# ● Recommendation Report

Application No. BE/52/11

**Proposal: Ground floor extension (re-submission following BE/36/10/).**  
**Site: 1 David's Close, Bognor Regis, West Sussex PO21 5TR.**  
**BE/52/11/**

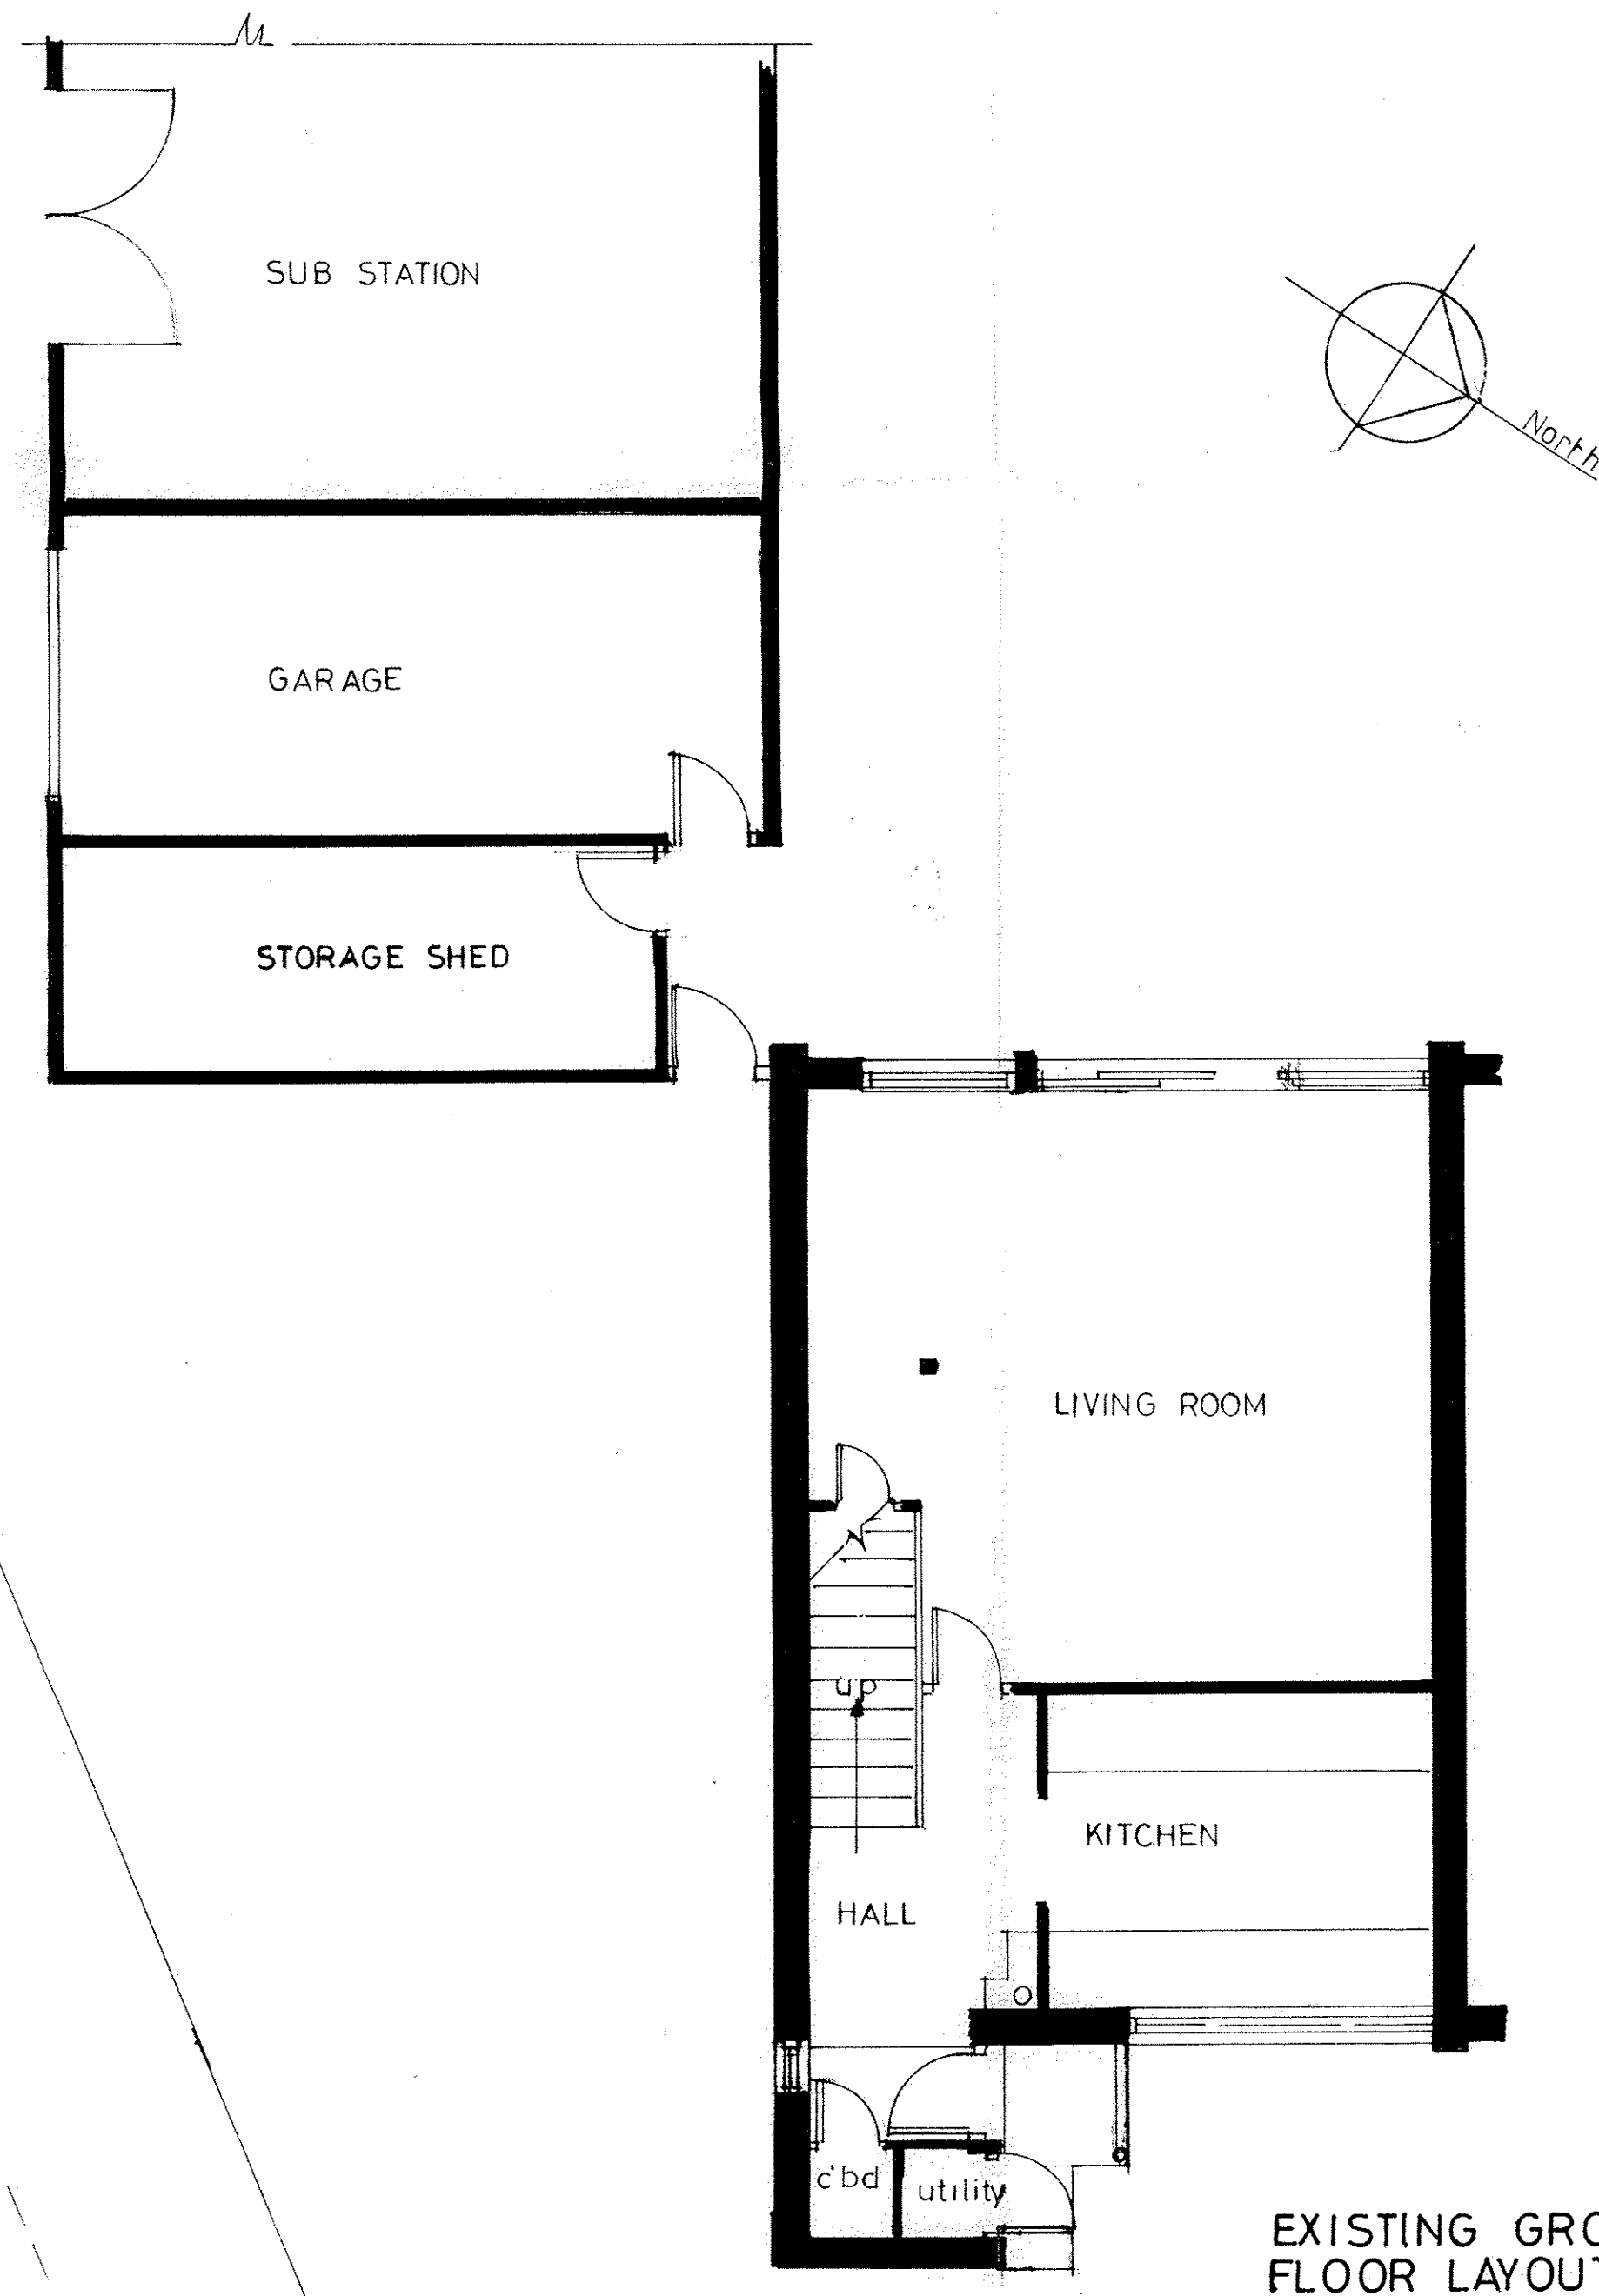
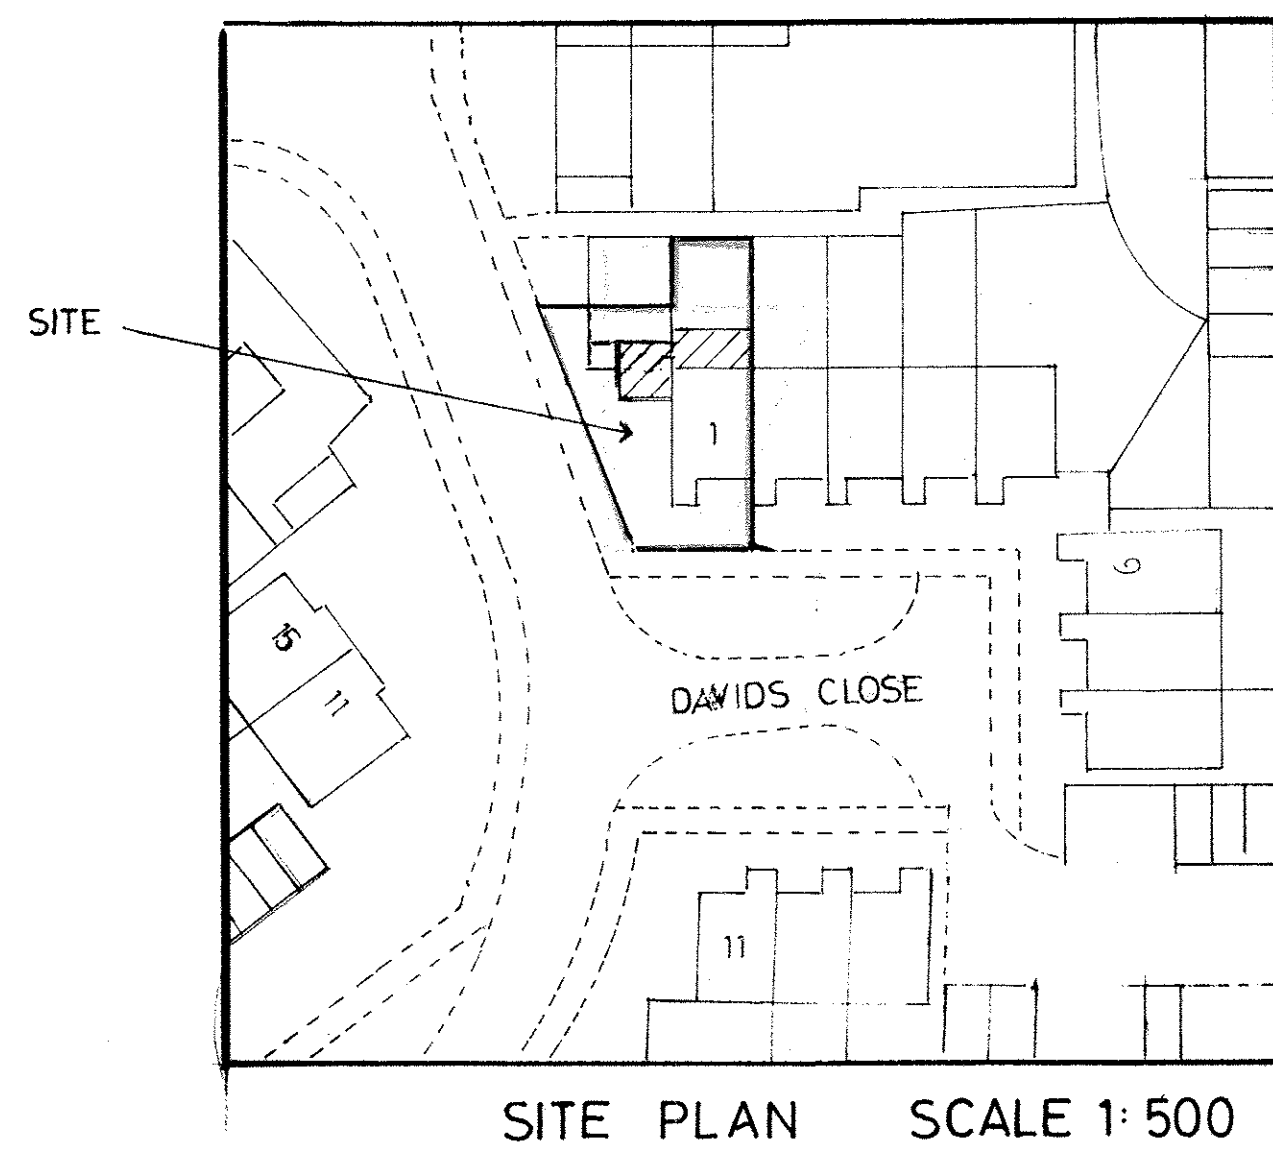
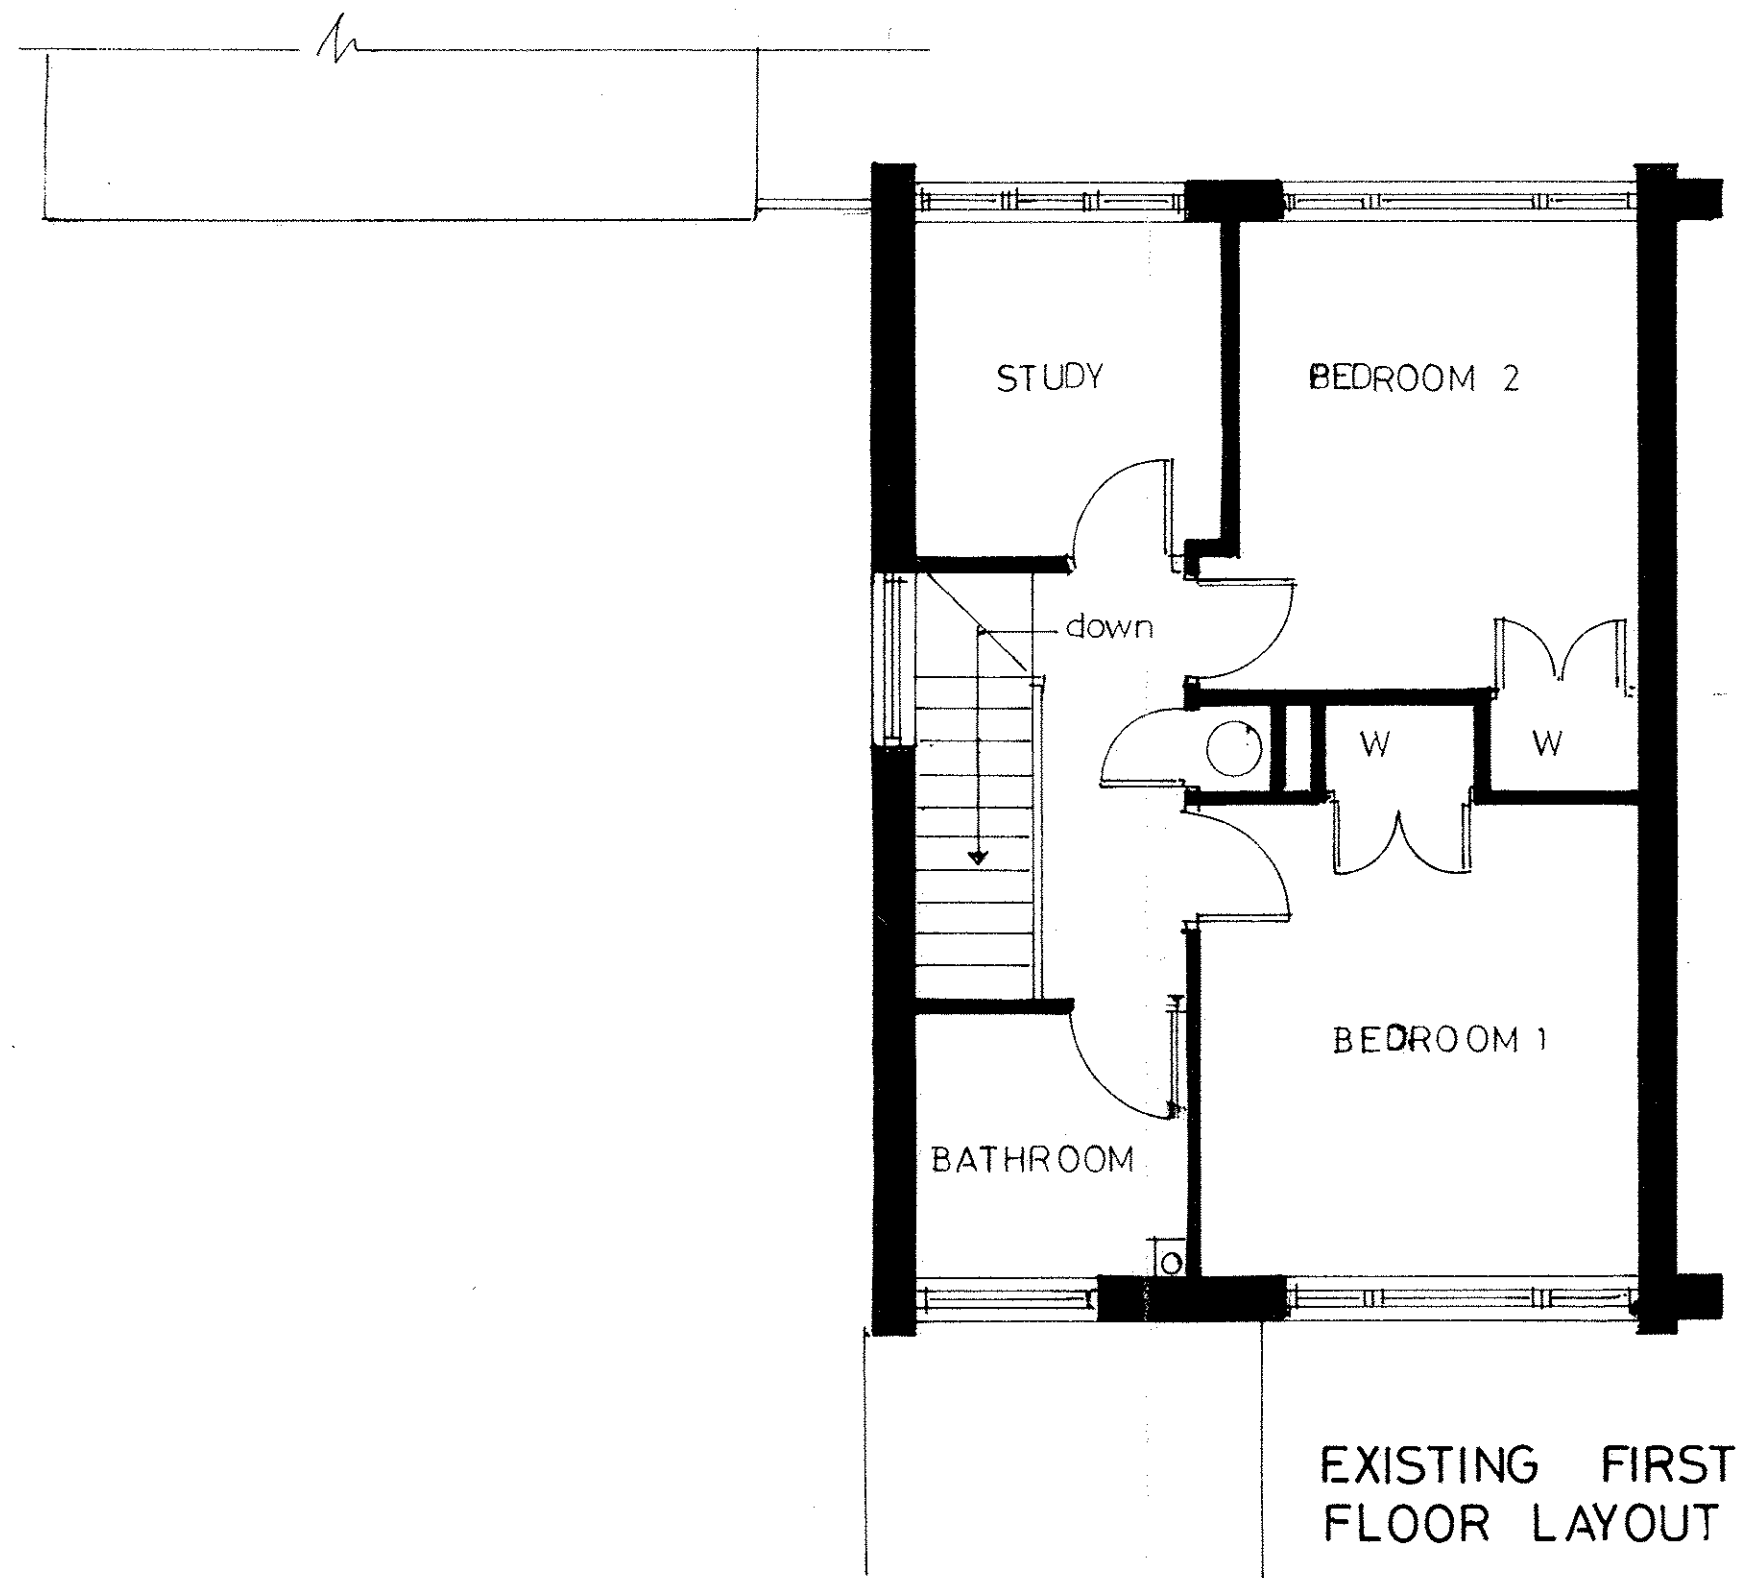
Please note that there are a 150mm public foul sewer crossing the site. No development or new tree planting should be located within 3 metres either side of the centreline of the public sewer and all existing infrastructure should be protected during the course of construction works.
